**Re: Request advice on the RTS for SSD-58978472 – Kelso Crescent Multi-Level Warehouse, Moorebank**

## Attachment A – Detailed comments

### 1. Urban Design

scale	As indicated	A1
project no	250211	
date	08.10.25	
dwn	SP	
dwg no	250211 - DA-301	
issue	A

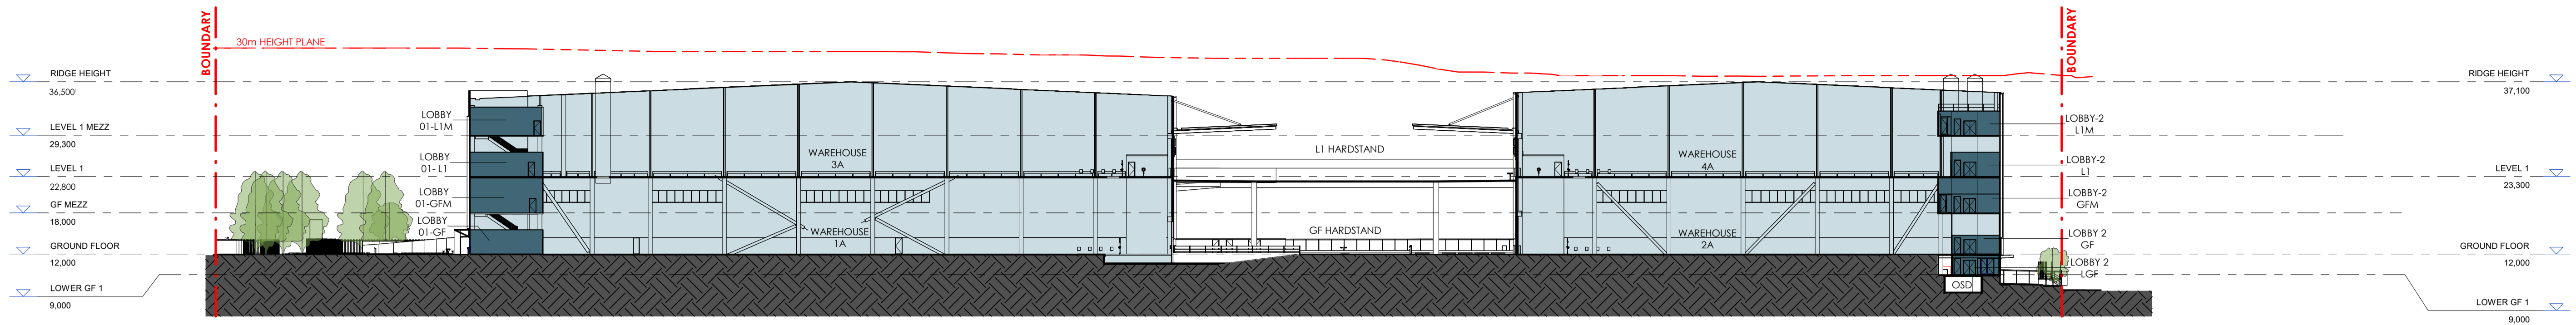
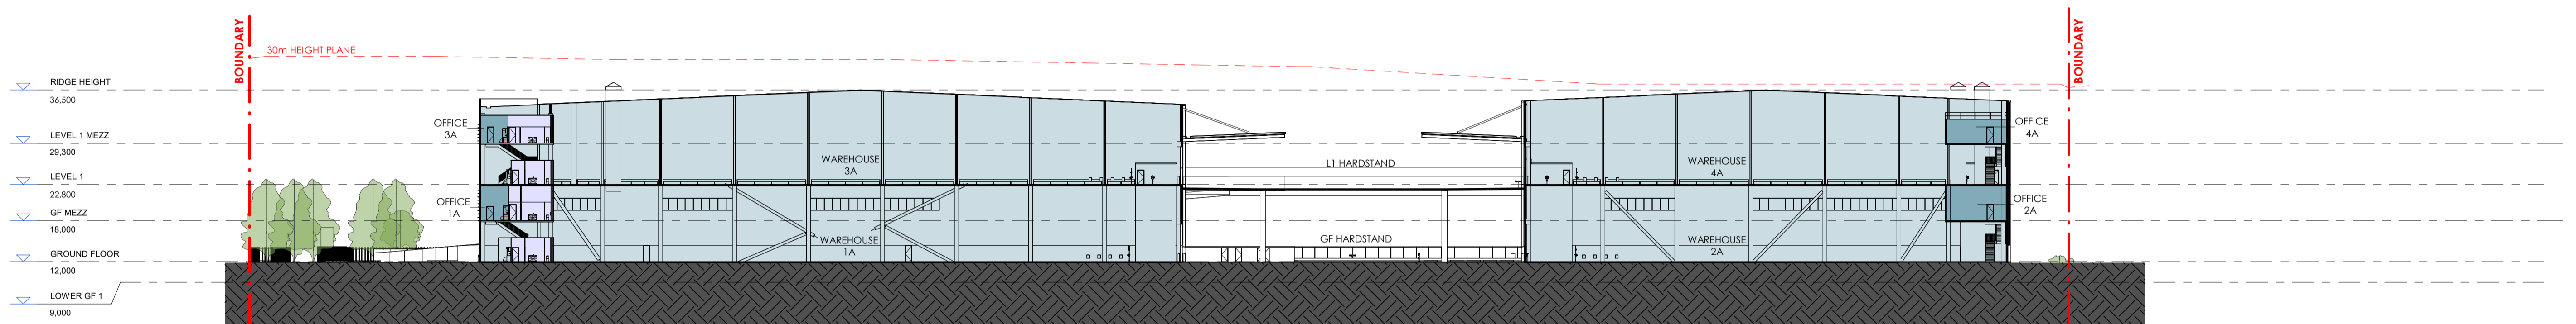
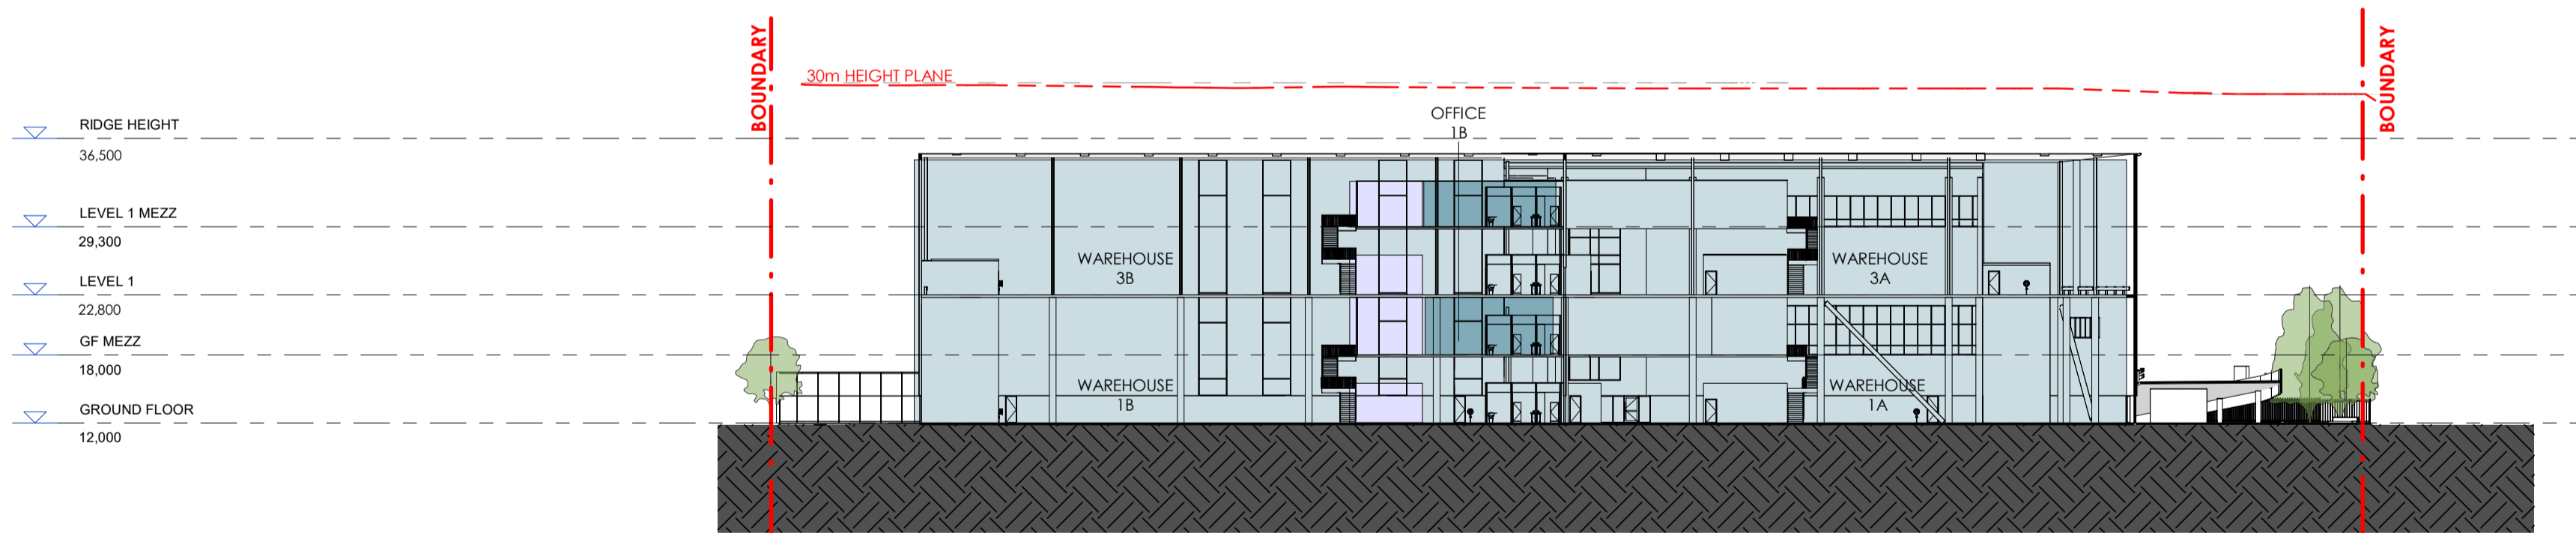
<p>above an easement can be a maximum of 4m, and the Endeavour Energy comments restricts trees altogether.</p> <p>Therefore, CDPD requests clarity on how trees will be provided to comply with the DCP, 1 per 30sqm, and capable of achieving a height greater than 8m.</p> <p>In addition, CDPD questions whether the full easement should be included in the 10% landscaped area, since it cannot provided landscaping in the way other areas can, and suggests to achieve adequate landscaping on this site, only half of the easement area be included.</p>
<p><b>Ground Levels</b></p> <p><i>Requests the applicant investigate the ground levels, prioritising the level transition at the street interface, and propose a ground level more aligned with the street. If the ground level is not lowered, then justification for the levels should be provided to Council to review. Requested the applicant show the existing ground line dashed on the sections, to enable for a review of the proposed levels and whether it is appropriate for the site and street interface.</i></p>	<p><b>Not addressed</b></p> <p>The Response to RtS states 'existing ground line shown dashed on DA-301 C' however the last DA-301-Sections drawing Urban Design reviewed was in the initial review, and it was Issue D and did not have the existing ground line. The latest drawings do not include a revised DA-301.</p> <p>Flood levels justification is acknowledged.</p>
